REVISION/DEFERRED SUBMITTAL FORM

Revision Log

Permit: #2012-200

Project Address: 3310 97th Ave SE, Mercer Island, WA 98040

1 FOUNDATION PLAN
1/4" = 1'-0"

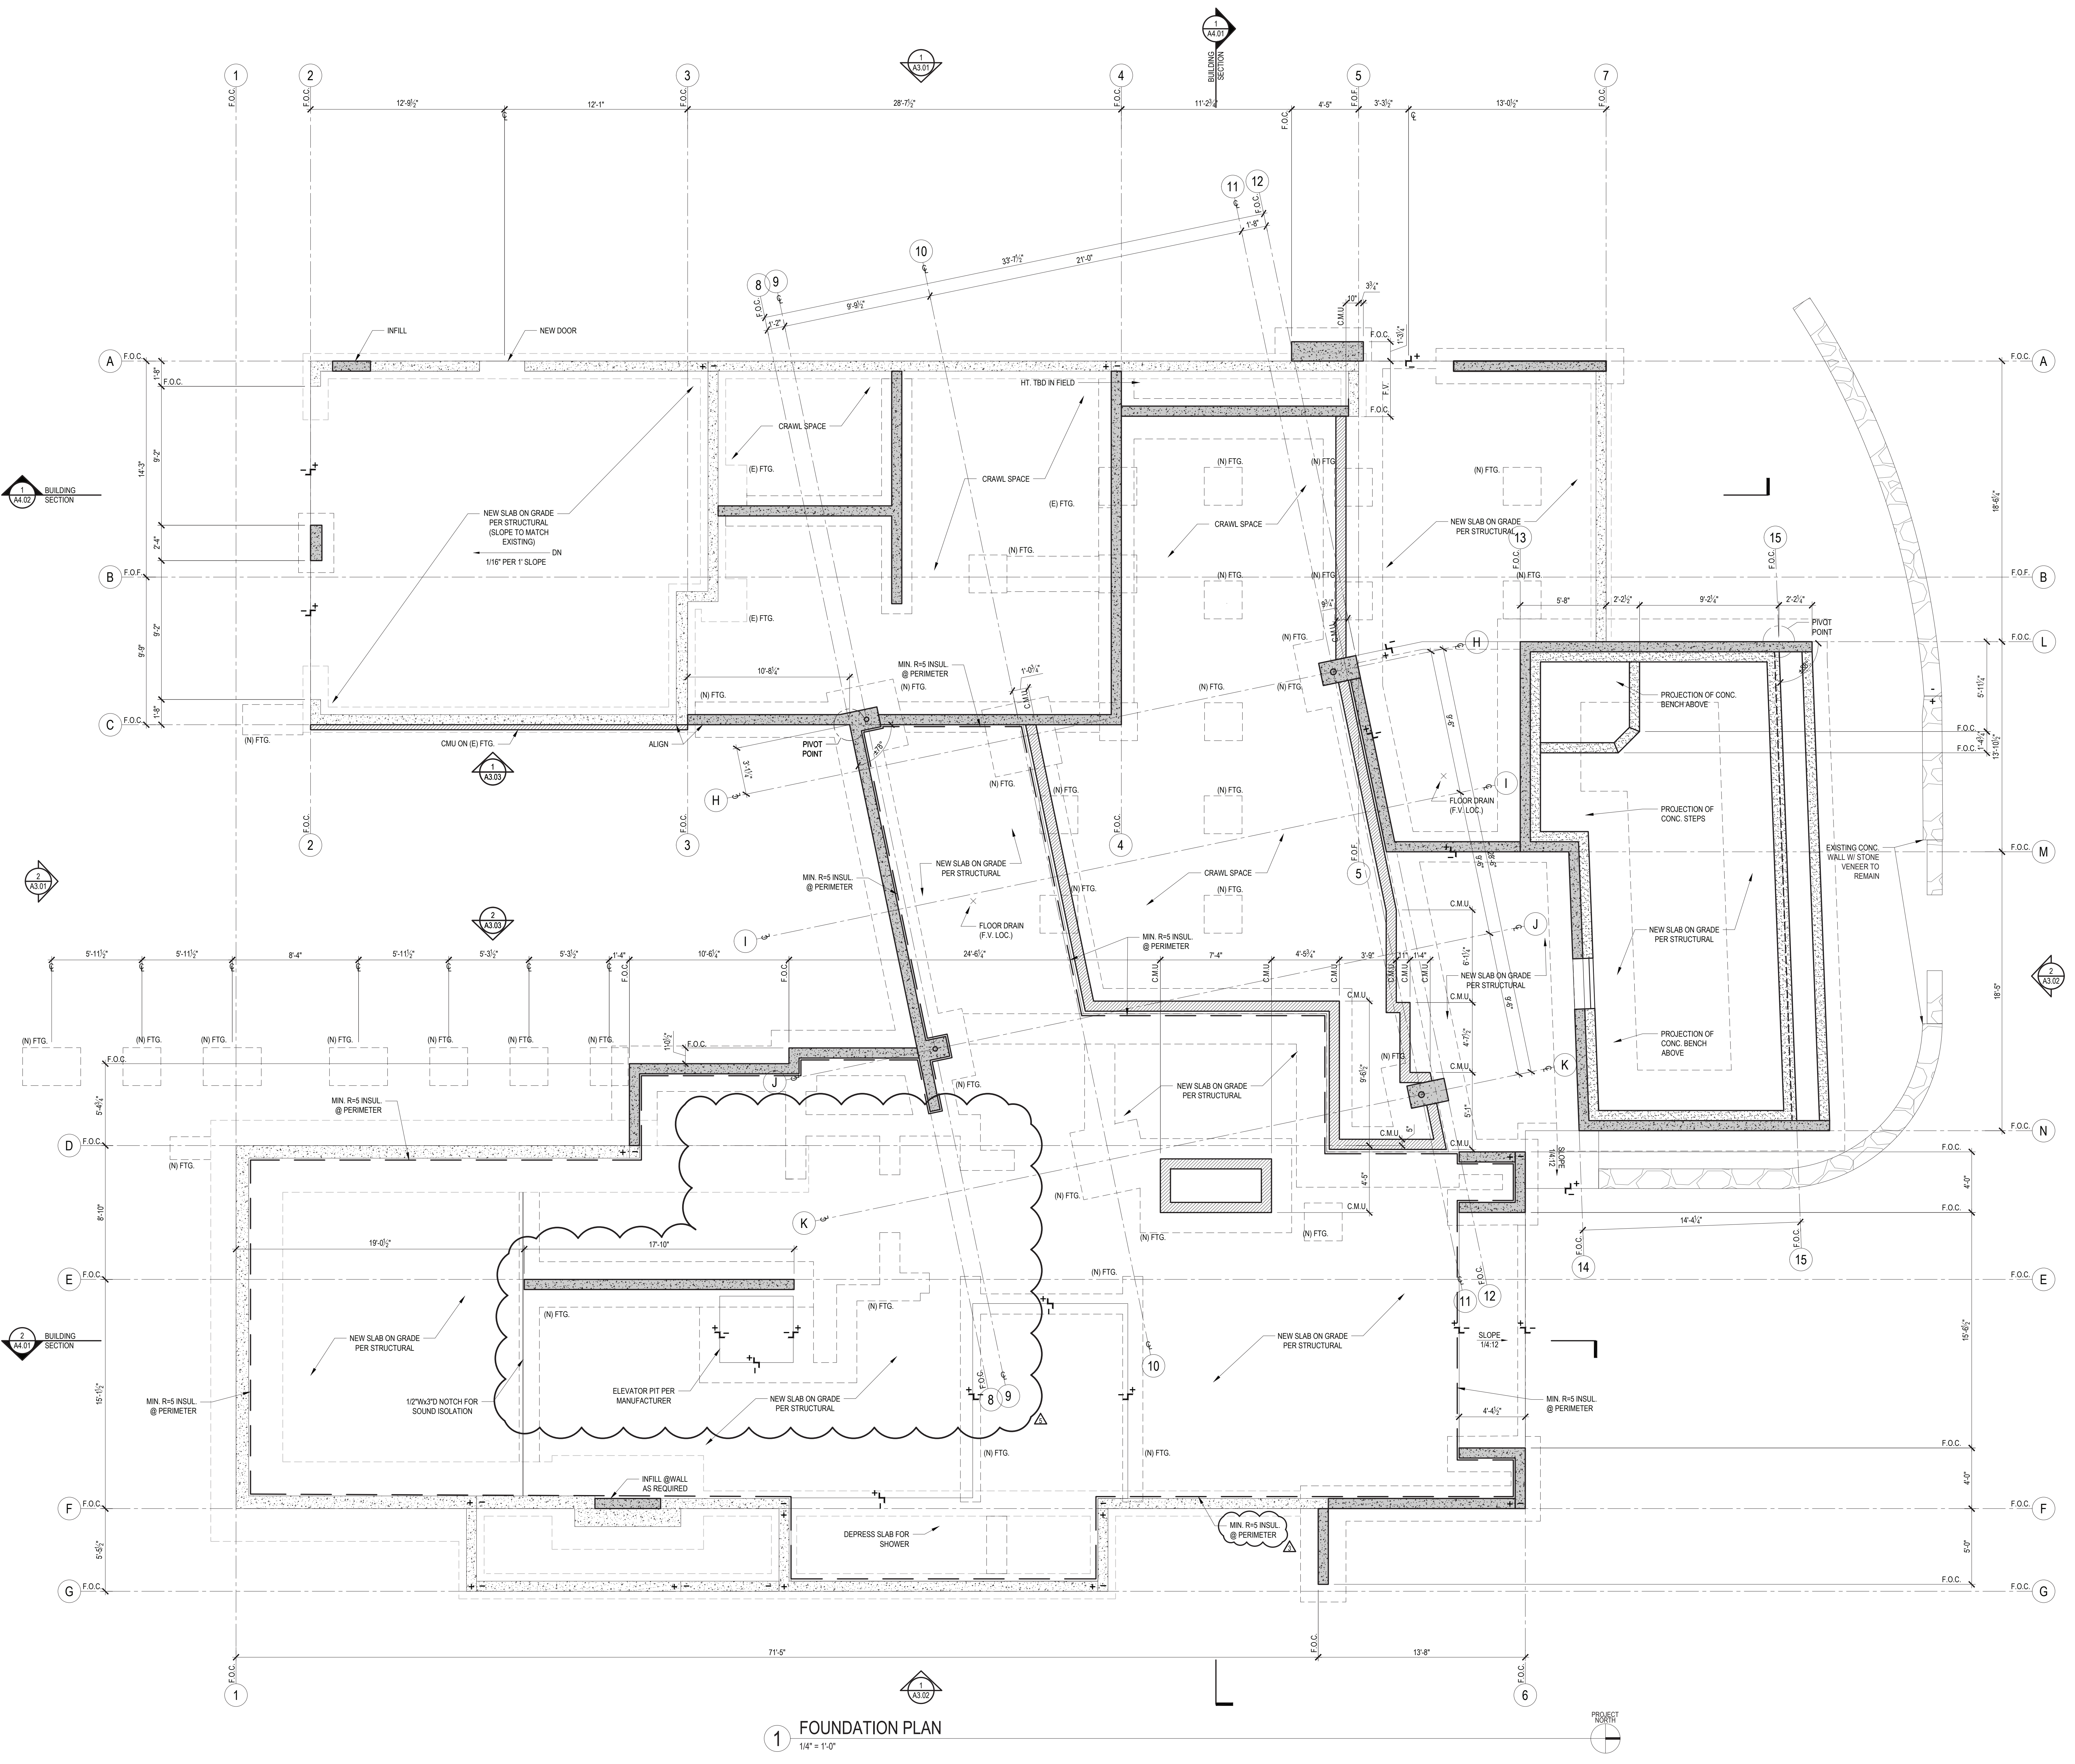
- Revised the foundation layout around new elevator and relocated rooms
- Added note #6

1 LOWER LEVEL DEMO PLAN
 1/4" = 1'-0"

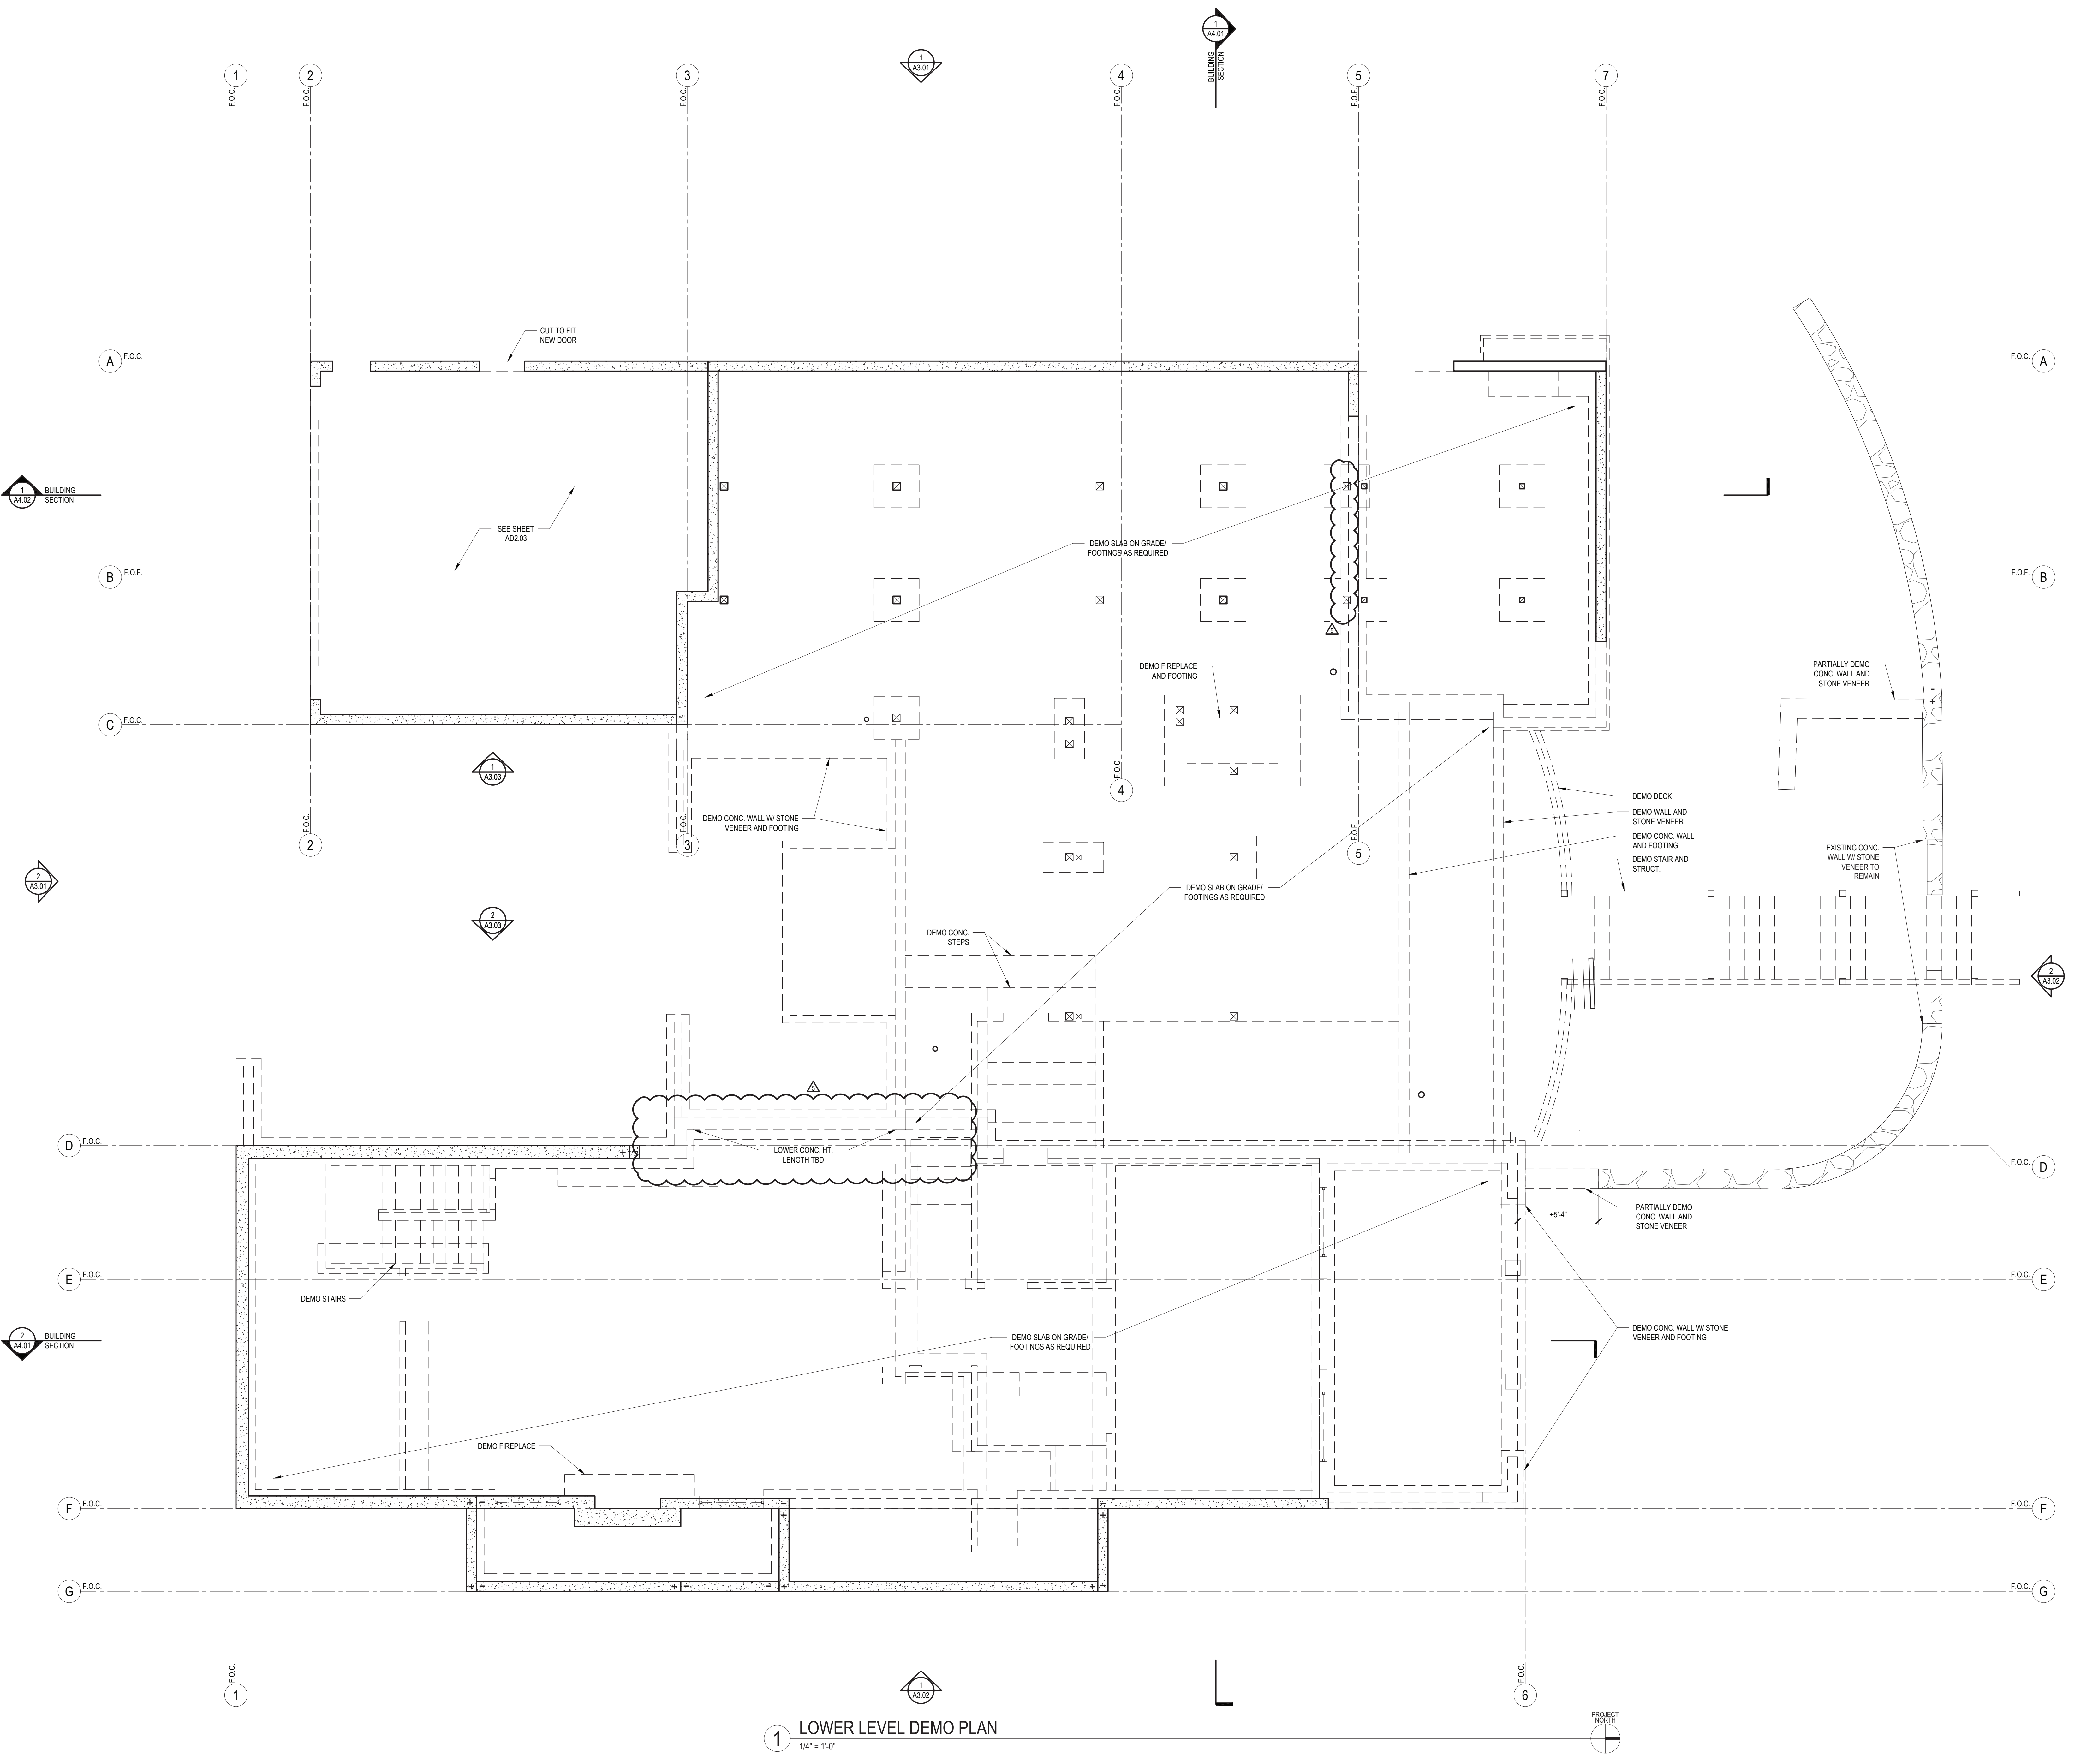
- Demolished more foundation at east wing crawl space for relocated POWDER 013 and KITCHENETTE 017

1 LOWER LEVEL FLOOR PLAN
1/4" = 1'-0"

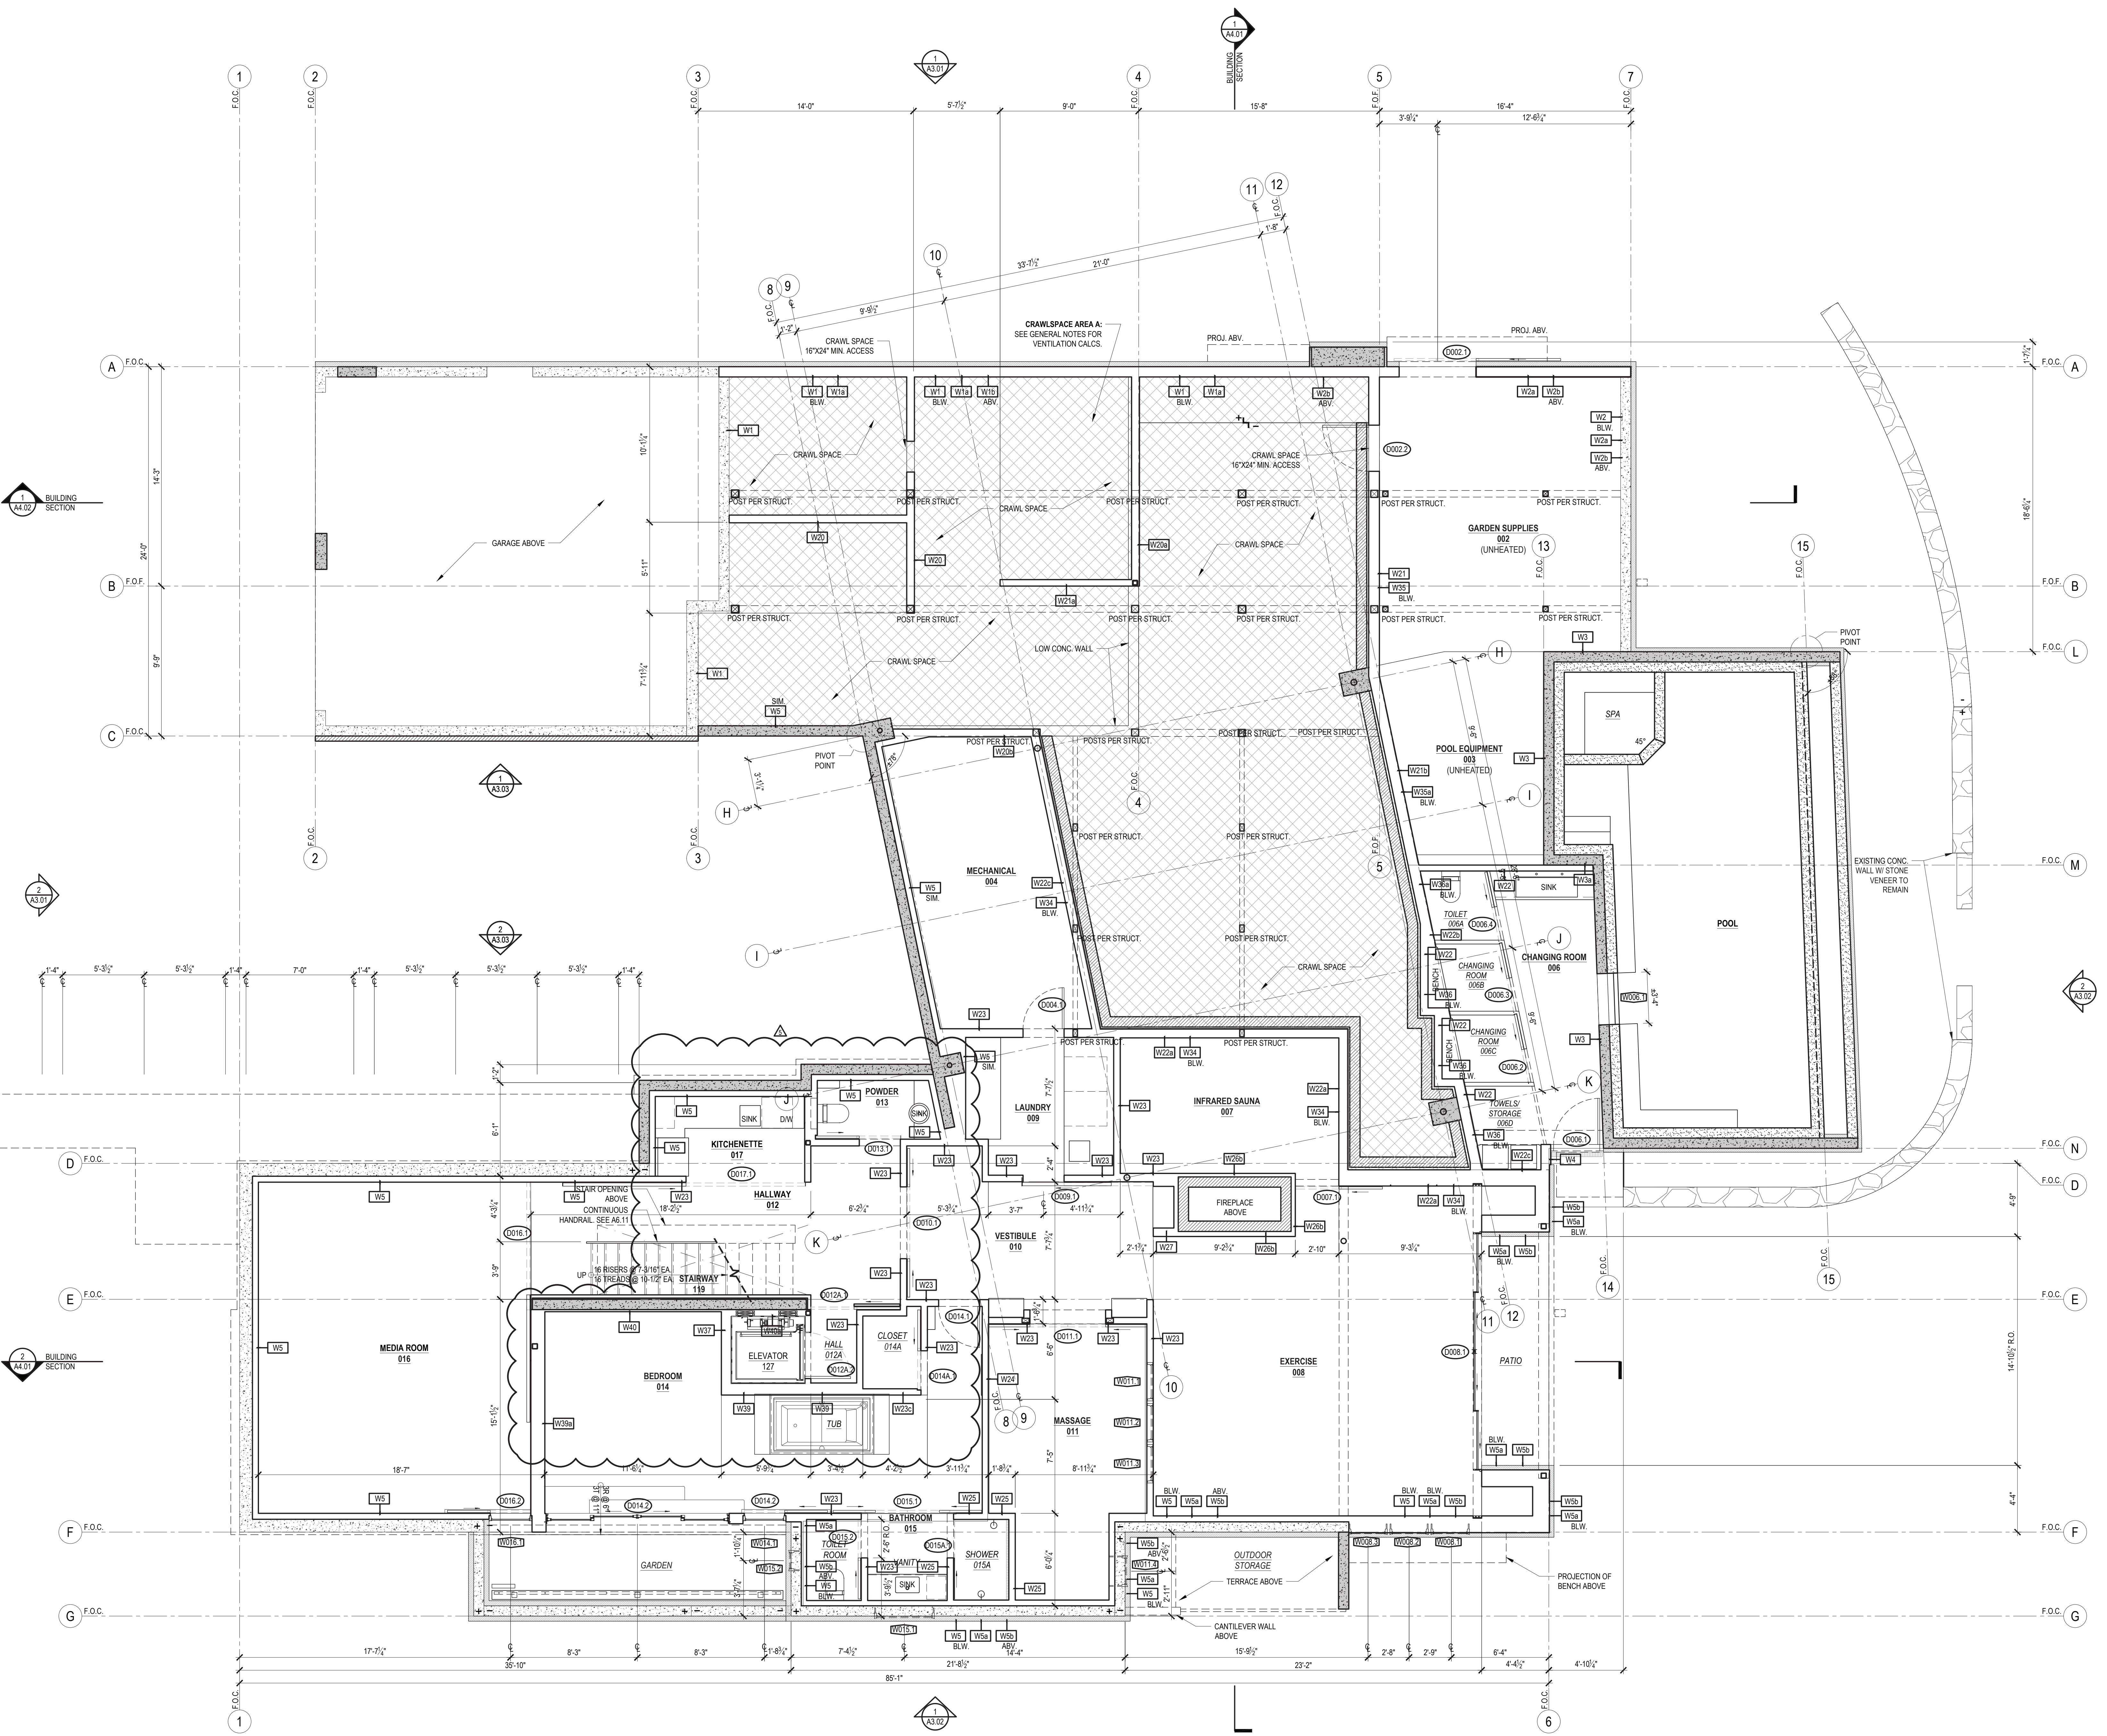
- Revised the floor plan to add ELEVATOR 127 and HALL 012A
- relocated POWDER 013, CLOSET 014A and KITCHENETTE 017

- Changed wall layouts between 016 and 014
- Added note #6
